From: Plant, Tom - Communities <Tom.Plant@Oxfordshire.gov.uk>
Sent: 14 May 2021 20:07
To: James Kirkham <James.Kirkham@Cherwell-DC.gov.uk>
Cc: Transport CDC Minor <Transport.CDCMinor@Oxfordshire.gov.uk>; Planning <Planning@Cherwell-DC.gov.uk>;
Cllr George Reynolds <George.Reynolds@Oxfordshire.gov.uk>
Subject: 21/00922/OUT - Land West Of Foxden Way Great Bourton OX17 1QY

Planning application:	21/00922/OUT
Location:	Land West Of Foxden Way Great Bourton OX17 1QY
Description:	OUTLINE Planning Application for up to 9 entry-level affordable houses - all matters reserved save for access
Type:	Outline Application
Case Officer:	James Kirkham

Oxfordshire County Council, as the Local Highways Authority, hereby notify the District Planning Authority that they **object** to the granting of planning permission.

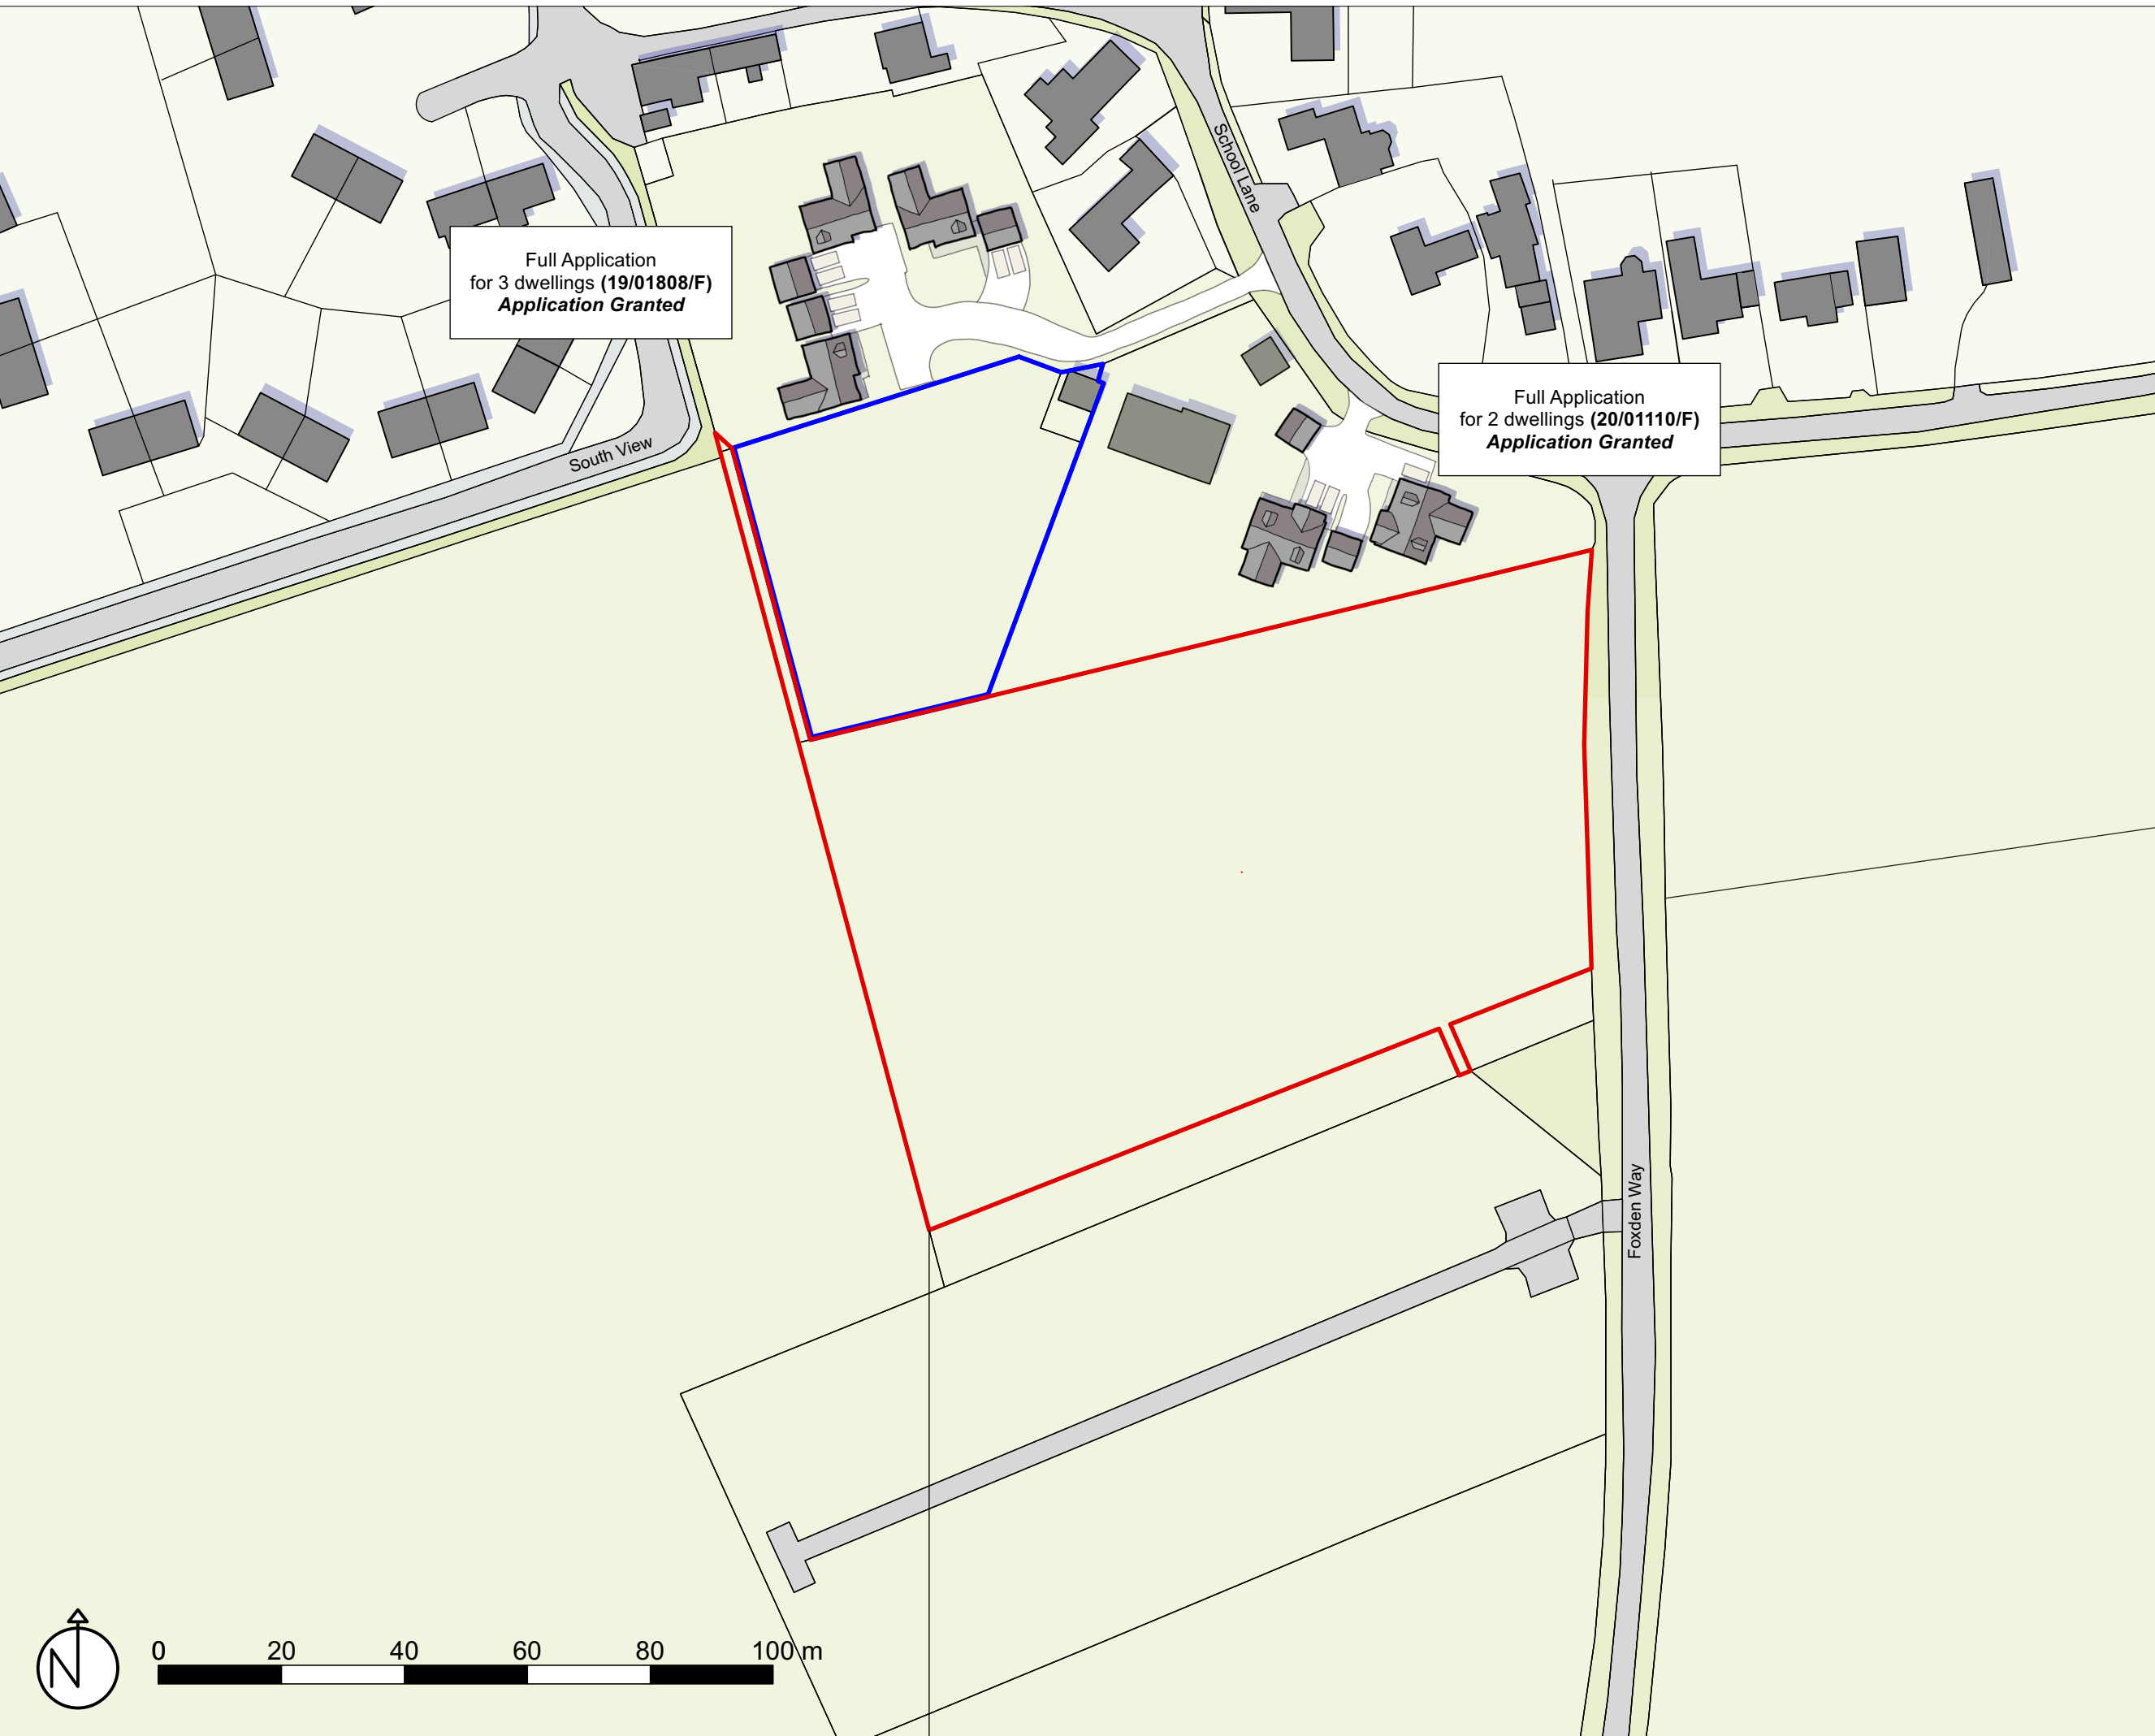
It is proposed to provide access for vehicular traffic to the site via a simple priority junction out onto Foxden Way. Pedestrian access is shown indicatively on the submitted plans, showing a connection out onto South View. However, the pedestrian access shown on the illustrative masterplan (drawing P01), has not been submitted for consideration here as the proposal is in outline only, and the submitted site location plan (drawing L01), does not show the redline abutting the existing highway infrastructure found on South View.

Notwithstanding the lack of any proposed pedestrian infrastructure out onto Foxden Way North towards the village, it is proposed by the applicant on the illustrative masterplan drawing P01, that pedestrian infrastructure could be provided to the rear of the site, via a connection out onto South View. However, this drawing is not subject to this assessment, and drawing L01 does not show the redline abutting directly with the existing highway infrastructure or highway verge here found on South View.

Given the deficiencies with the lack of pedestrian infrastructure proposed from the site onto Foxden Way, and with the pedestrian route via South View shown only indicatively, the only pedestrian route currently proposed will require access to all the village services to be accessed only from walking within and through the junction of Foxden Way, Crow and School Lane. This pedestrian access to the rear must therefore be included at outline stage and included within the scope of the 'access' assessment of this planning application. Failure to secure this access provision at this initial stage runs the risk that the access as shown on drawing P01 may never be fulfilled. Therefore, without this inclusion, the proposal fails to provide for a safe pedestrian access route from the site to the village, contrary to paragraphs 108 (a), (b), (c), and 110 (a), (b), (c) of the NPPF 2019. – **Reason for objection.**

Phoenix 2-23W (with Elite 2 6x2 RS chassis)
 Overall Length 10.520m
 Overall Width 2.530m
 Overall Body Height 3.211m
 Min Body Ground Clearance 0.416m
 Track Width 2.530m
 Lock to lock time 4.00s
 Kerb to Kerb Turning Radius 7.500m

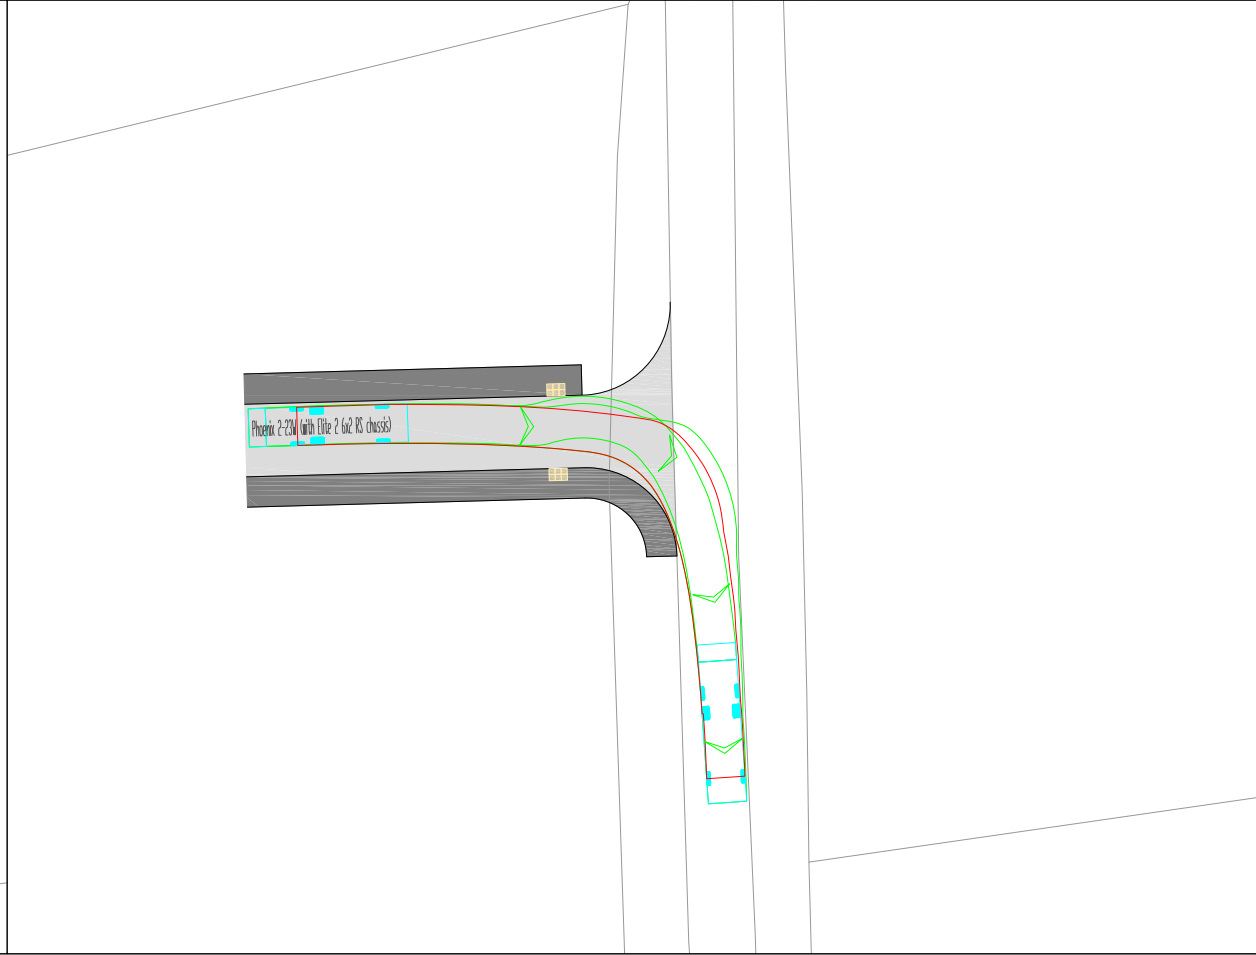
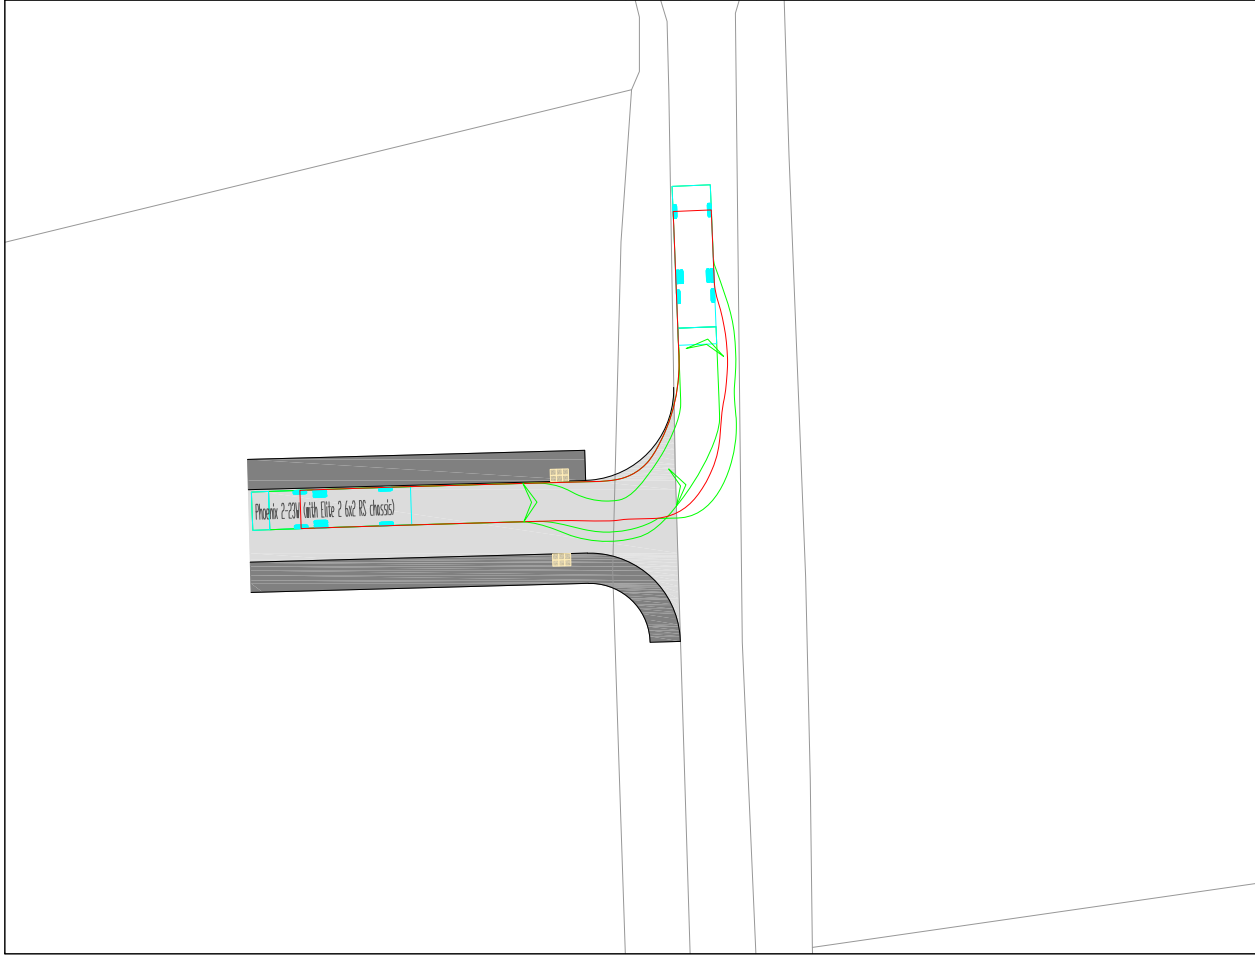
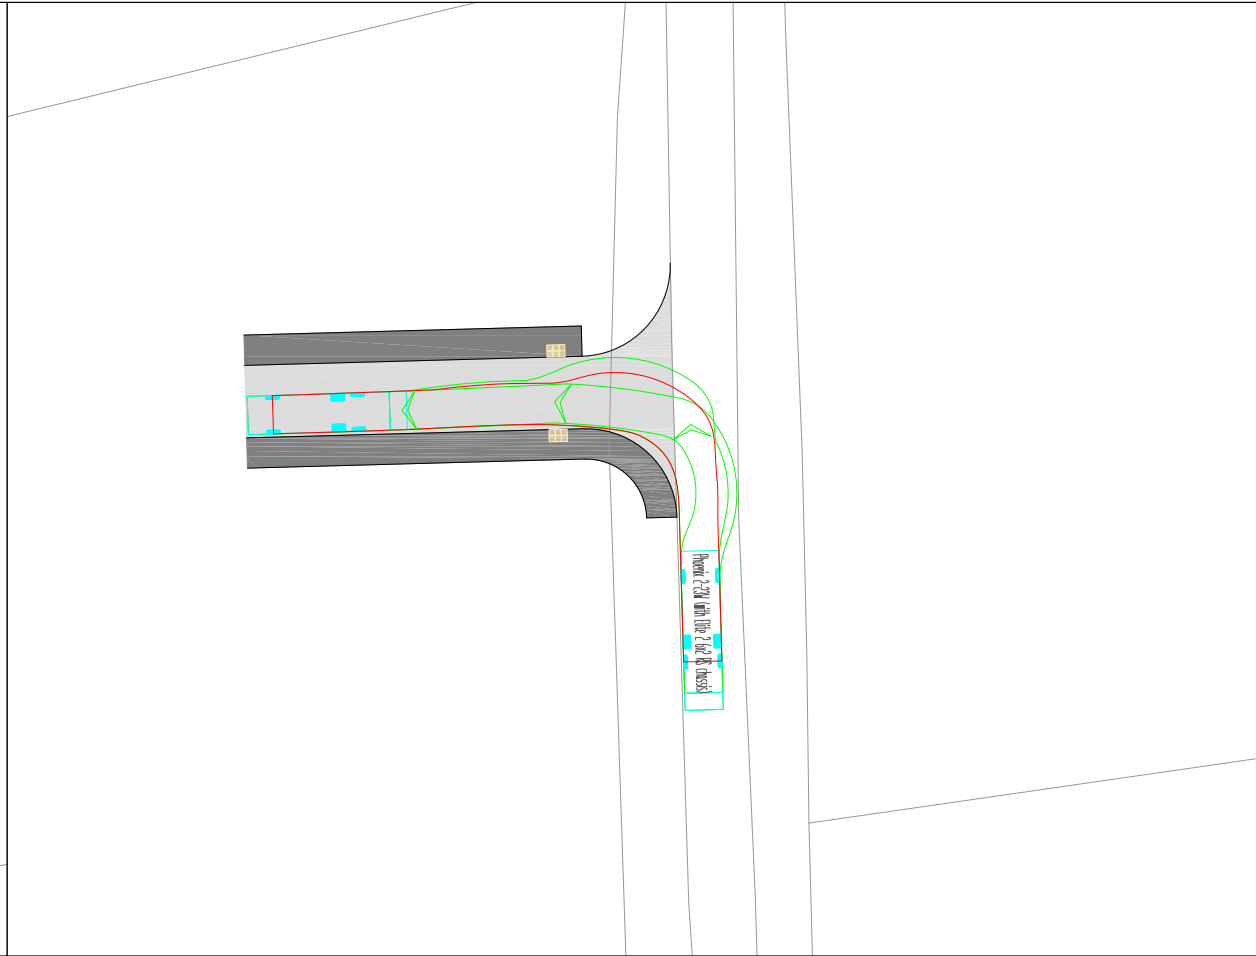
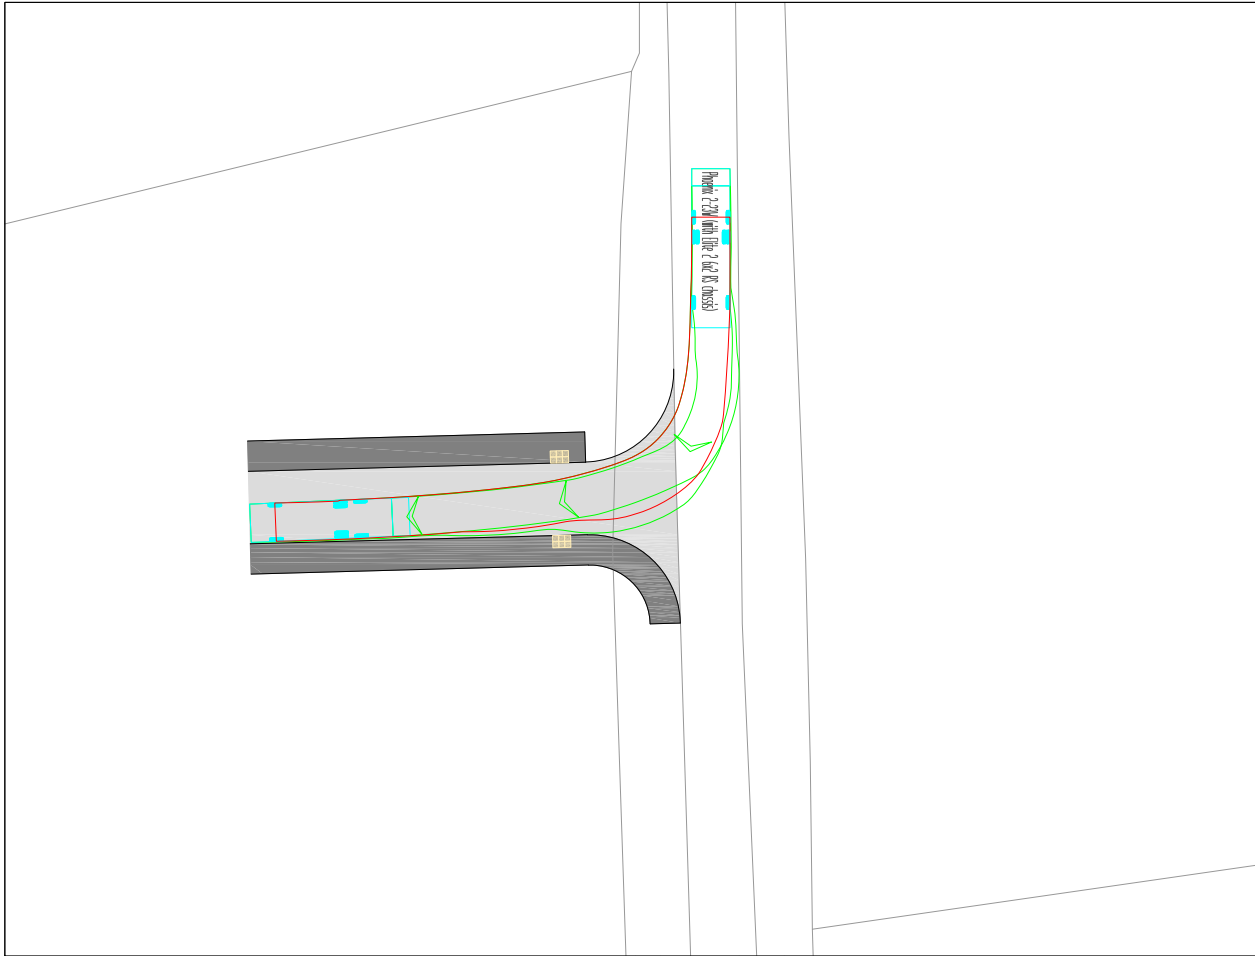
The applicant has submitted drawing 002 Rev A, swept path analysis, to demonstrate how a refuse vehicle will access this site. Drawing 002 Rev A shows a swept path analysis for a 10.5m Phoenix 2-23W refuse vehicle. Please note, the dimensions used here for this assessment fall over 1m too short to be considered acceptable. Swept path analysis of 11.6m refuse vehicle as used by Cherwell District Council must be demonstrated. Therefore, as submitted, the applicant has failed to

demonstrate whether the site can accommodate a Cherwell refuse vehicle, contrary to paragraph 108 (b), and 110 (c), (d) of the NPPF 2019. – **Reason for objection.**

Please note, at the time of my site visit, I was concerned to see significant verge overrun on both sides of the highway. It therefore concerns the LHA that it would appear from drawing 002 Rev A that with only exceptional technical ability, that the manoeuvre as shown into and out of this access will not occur without any overrun of the highway verge. However, with only a 10.5m vehicle tracked, it is therefore expected significant vehicle overrun will occur. Vehicle overrun is unacceptable and must be avoided, or suitable mitigation measures proposed in line with paragraph 108 (c) of the NPPF 2019. – **Reason for objection.**
